**Consultation Response from Mike Hibbert,  
KC Waste Strategy( Refuse & Recycling)**

**2023/91491 Prickleden Mills, Woodhead Road, Holmfirth, HD9 2JU**

**Date Responded: 28/06/2023.**

**Responding Ref: WPS23-035**

2659 (100)10 /

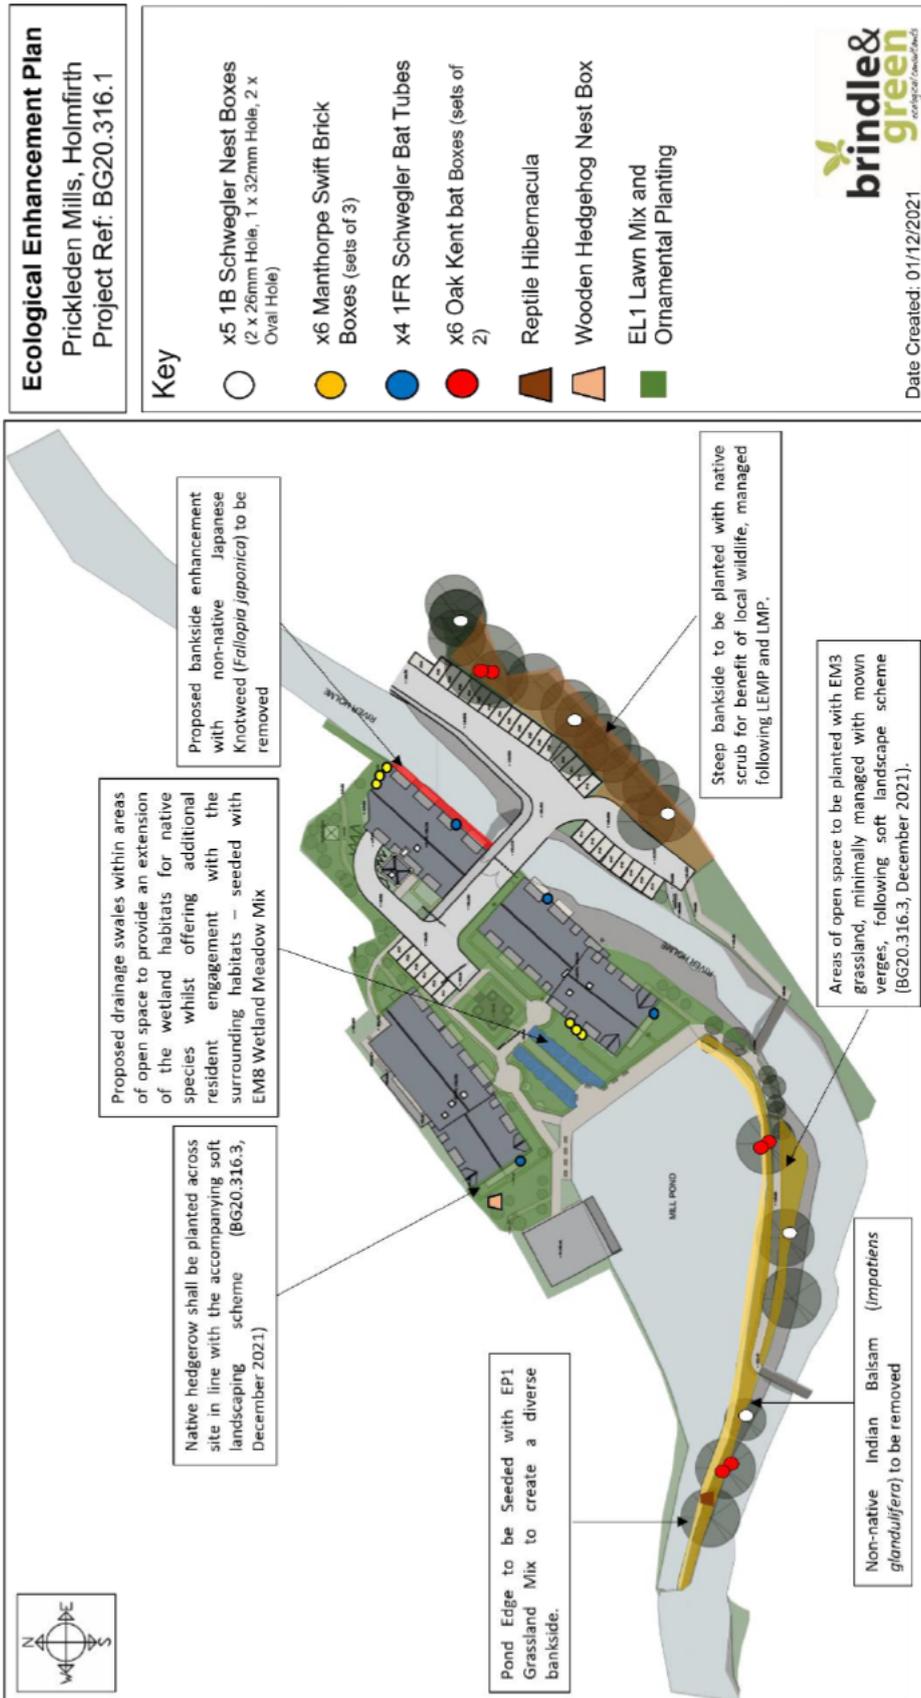
- It is not clear on the plan where Bin Collection Point(s) close to the turning head will be or how bins will be transferred from the under-croft stores to the BCP's.
- The Authority will not take an RCV into private drives or roads that are not built to adoptable standards.
